Our reference: ECM 9813259
Contact: Kathryn Saunders
Telephone: (02) 4732 8567

3 December 2021

**Response to Submissions: SSD-11070211 - Proposed New Public School
in Mulgoa Rise, Glenmore Park at 60-78 Deerubbin Drive and 1-23
Forestwood Drive, Glenmore Park**

Drawing Title
LANDSCAPE SITE PLAN
SCALE: 1: 750 @ A3

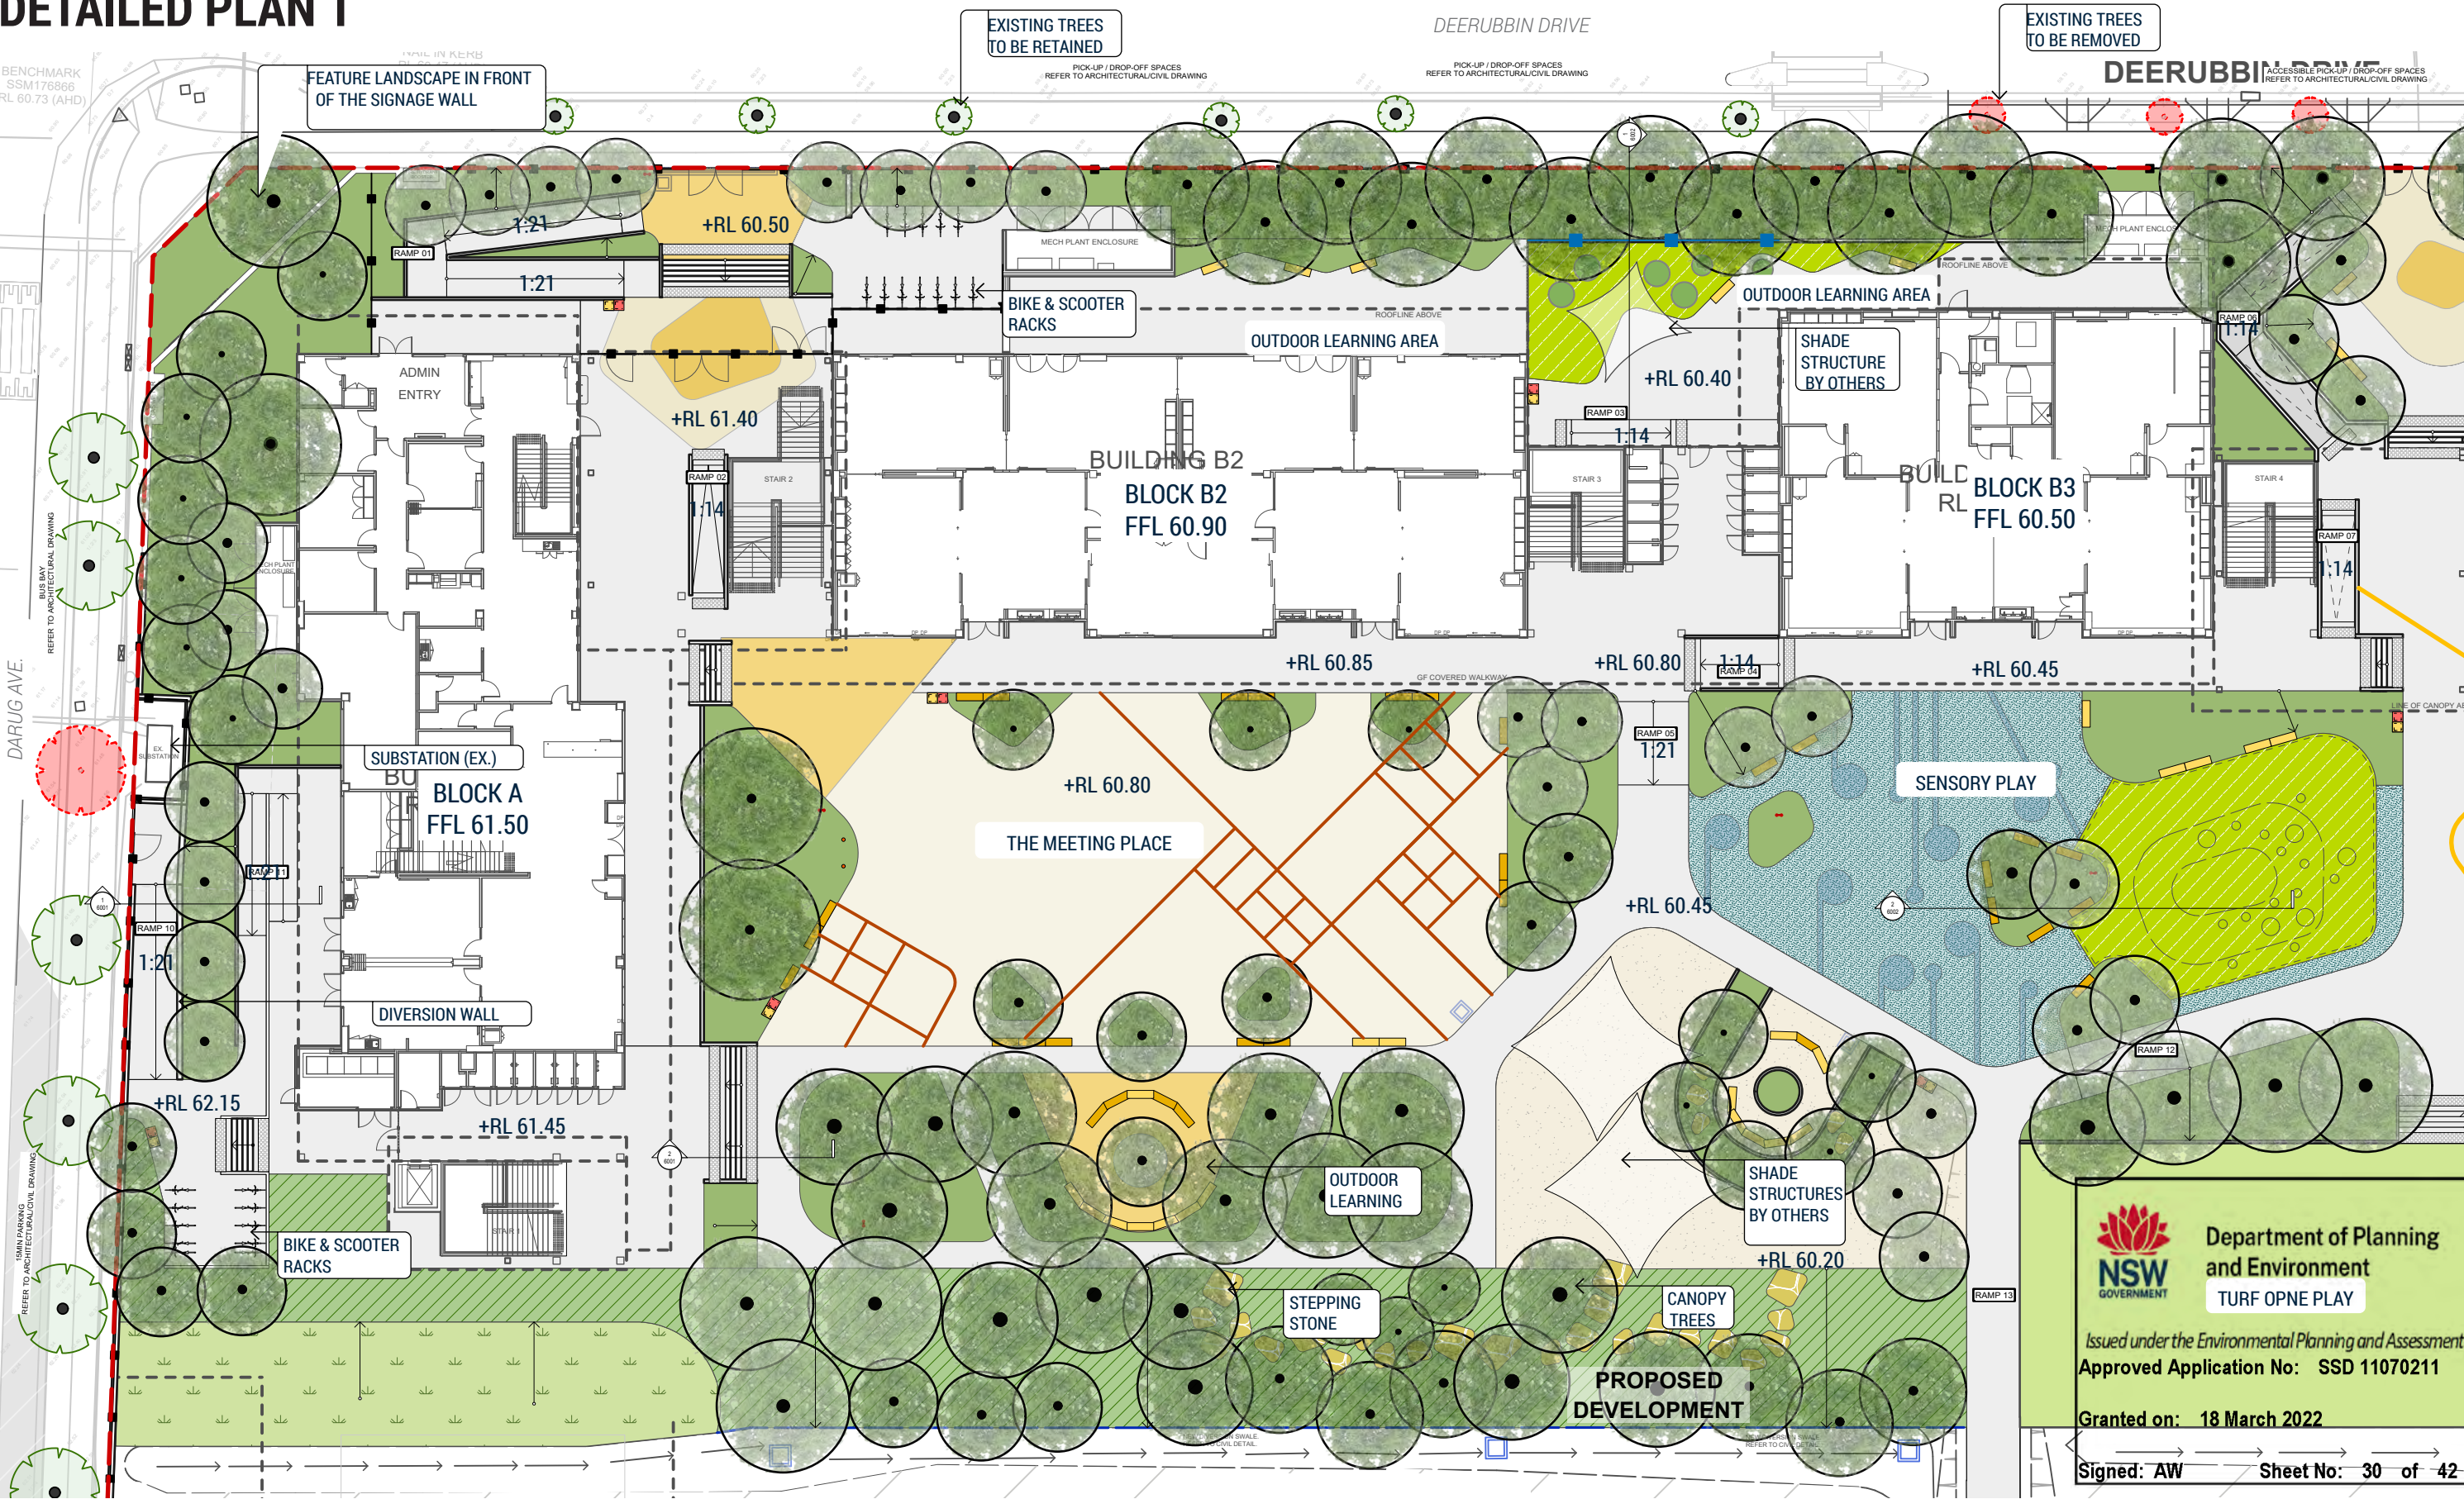
Fencing details are lacking - for streetscape amenity fences should be setback from the boundary with landscaping to reduce the visual impact of the fence.

Street trees are proposed to be removed to enable accessible parking bays.

These street trees should be replaced at a 2 for 1 ratio. Council supports street trees of a suitable size above and below ground in between kerb ramps at accessible parking bays. Additional street trees should be considered in the verge north of playing courts.

There is a lack of detail regarding tree species and the corresponding canopy dimensions on the plan. Whilst the canopy cover appears to meet targets, large tree species are not identified on the plan, nor their mature canopy spread represented on the plan.

Assuming the unidentified open space along the access to Forestwood Drive is intended for parking, additional shade planting is appropriate to cast shade onto pavement areas. A kerb edge is required to contain parking to formalized carparks. Overflow and unauthorized parking in landscaped areas compromises soil compaction and tree health.
